**Re: Lots 12 & 13 Block 6 Unit 5 Volcano Cliffs SAD 227
8009 & 8015 Victoria Dr. NW
Grading & Drainage Plan
Engineer's Stamp dated: 8-27-17 (E10D037)**

Based upon the information provided in your submittal received 9/5/2017, this plan cannot be approved for Building Permit until the following comments are addressed.

Lots 12, Block 6
Volcano Cliffs Subdivision, Unit 5
GRADING PLAN

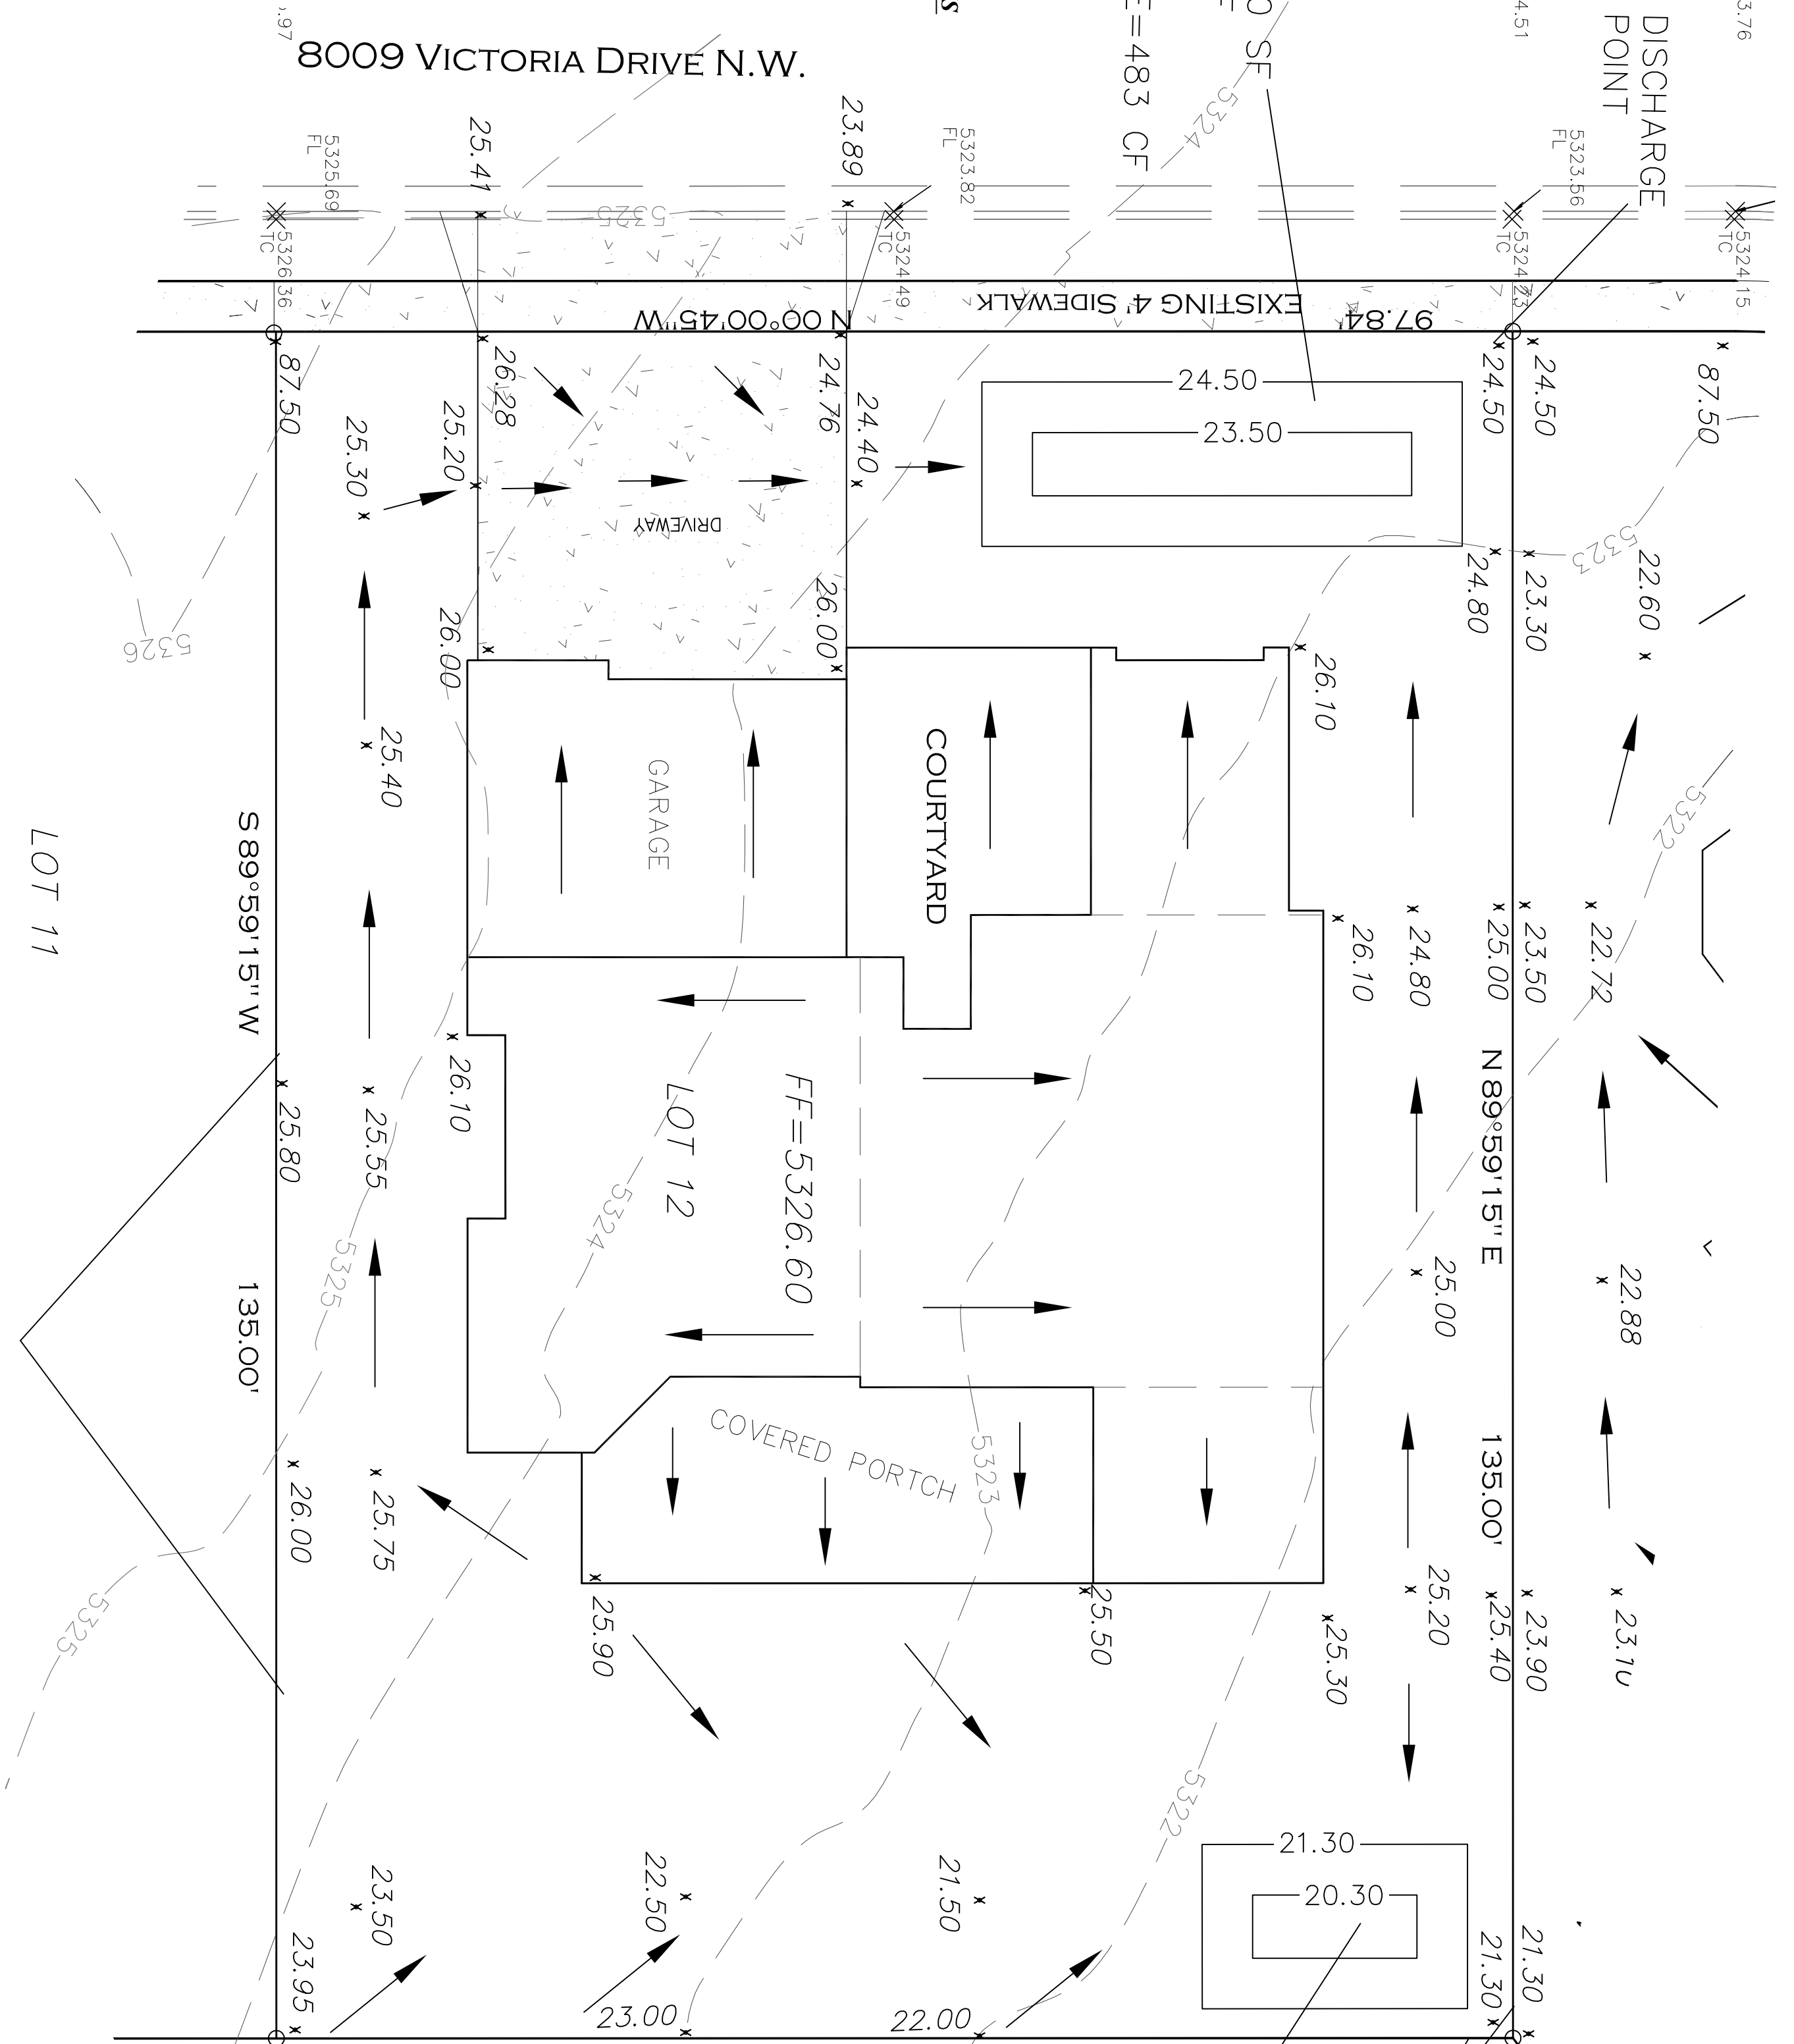
- Provide direction of roof flows. If flows are toward the front, how will these flows enter the ponding areas?
- Separate this one submittal into two submittals.
- Impervious area should be at 32%, or provide extra retainage for the larger area.
- Provide a table showing area's in percentage and in square feet.
- Provide how flows will cross the driveway and enter into the front yard pond.
- A pad certificate is required before a building permit is issued.
- Provide a statement on the plans that a separate permit is required for any retaining walls or garden walls.
- The weep holes are required to be 3" above grade.
